Keadby Development Consent Order

Written Representations on behalf of Network Rail

Figure 4: AIL Route using A18 to access the Proposed Development Site

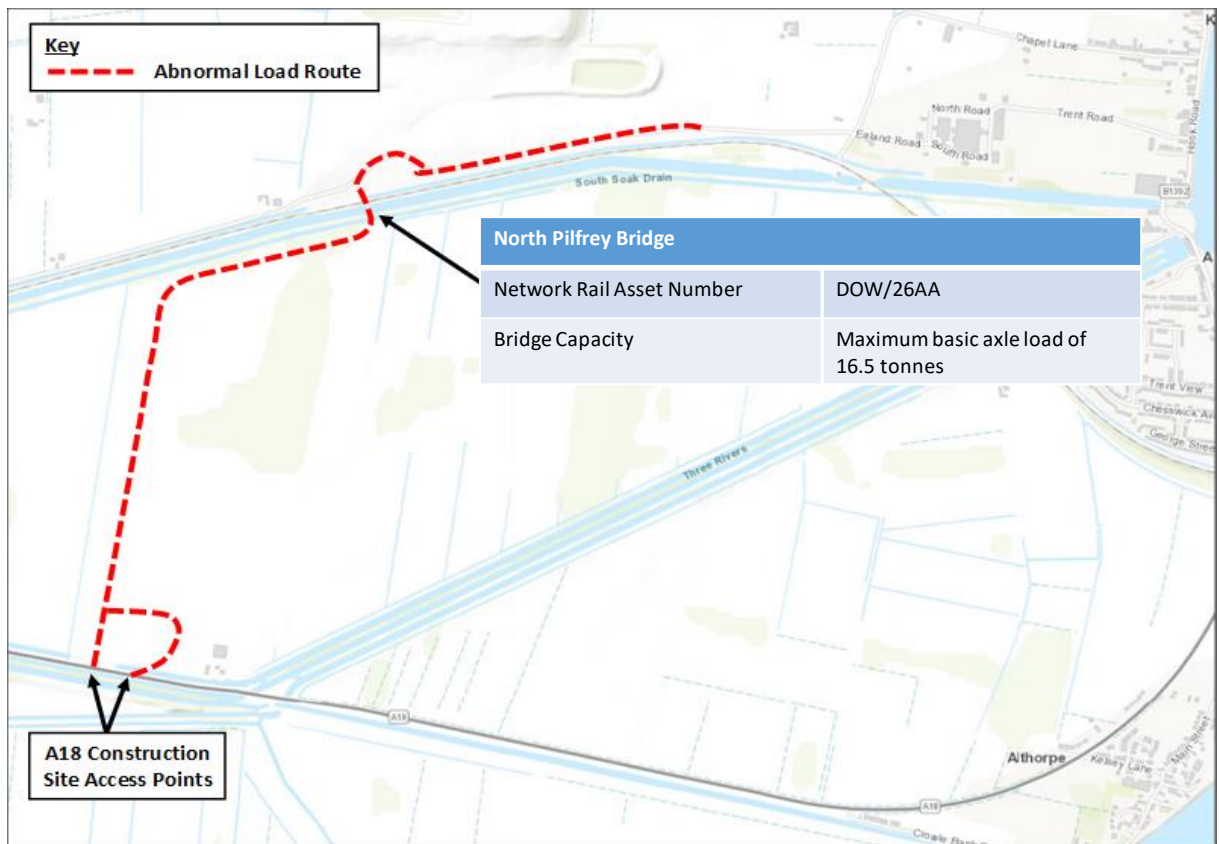
6.2.1.1 It is noted that the proposed works provide for the "potential resurfacing, maintenance or improvement of the existing track passing over the North Palfrey Bridge but no replacement, rebuilding or widening of the bridge or its parapets".

6.2.1.2 Network Rail would welcome clarity as to what would constitute 'improvement' to ensure that the full potential impact on the railway can be assessed.

6.2.2.1 any increased use of the Bridge must be carefully assessed to ensure that there is no adverse impact on the railway.

6.2.3.1 It is imperative for the safe operation of the railway that any works required to the bridge are carried out in such a way as to ensure that no material falls on to the railway.

6.2.3.2 Network Rail would like to understand what measures will be put in place during any required works to the Bridge to ensure that

- 6.2.6 any weight restrictions required:
 - 6.2.6.1 Network Rail are assessing whether any weight restrictions on vehicles using the Bridge are required in order to ensure the safety of the railway.

- 6.2.7 any traffic management over the bridge which needs be identified:
 - 6.2.7.1 Network Rail are assessing whether any traffic management measures will be required in relation to the Bridge to ensure the safety of the railway.
